**DEVIATION REQUEST
AND DECISION FORM IN
ASSOCIATION WITH A
REQUEST FOR A PUD
MODIFICATION FROM
THE ECM**

Project Name : Urban Landing Preliminary Plan

A deviation from the standards of or in Section **LDC 8.4.4 (E) (2)** and Section 2.2.4.B.7 Fig. 2-17, Table 2-7 and Section 2.3.8 of the Engineering Criteria Manual (ECM) is requested.

DESIGNED BY	MAW	SCALE	DATE	4/01/2024
DRAWN BY	MAW	(H) 1" = 40'	SHEET	3 OF 9
CHECKED BY	(V) 1" = N/A	JOB NO.	1308.01

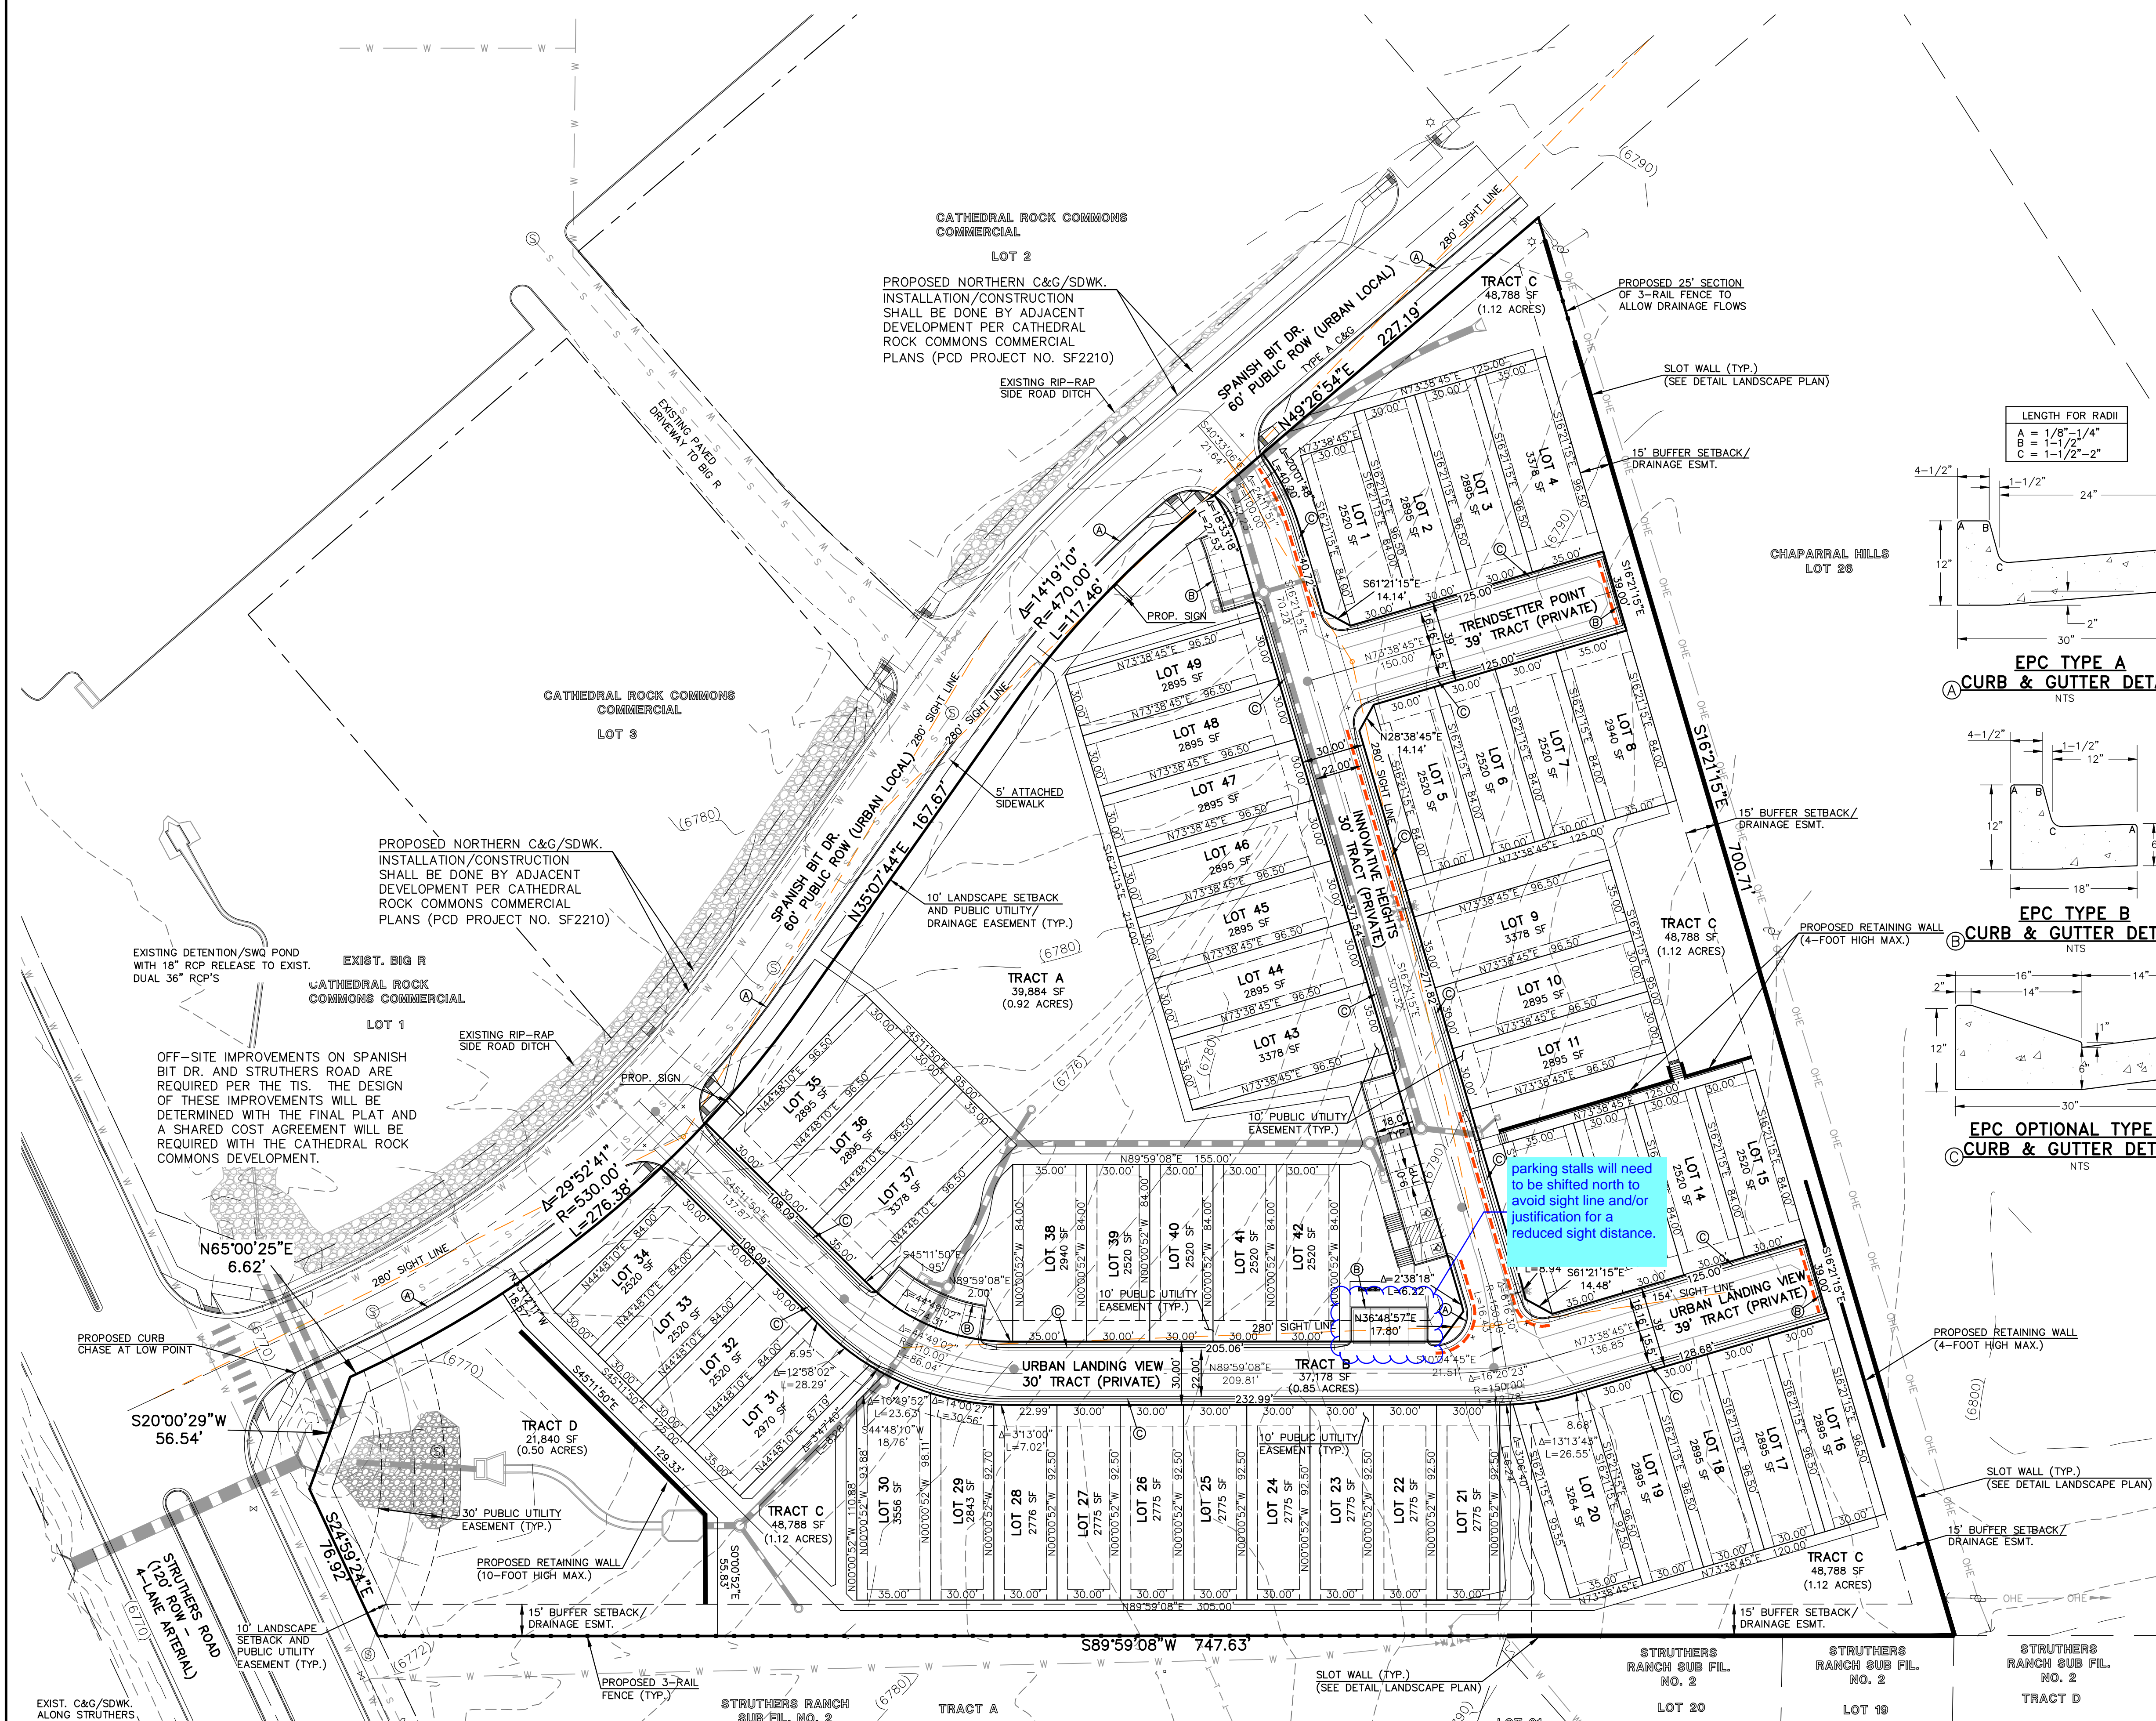
Please compare the proposed intersection spacing(134'?)vs the County criteria of 150'

As the private roads do not provide sidewalks please also discuss the Pedestrian access provided throughout the site. Also, discuss justification for the reduced intersection spacing.
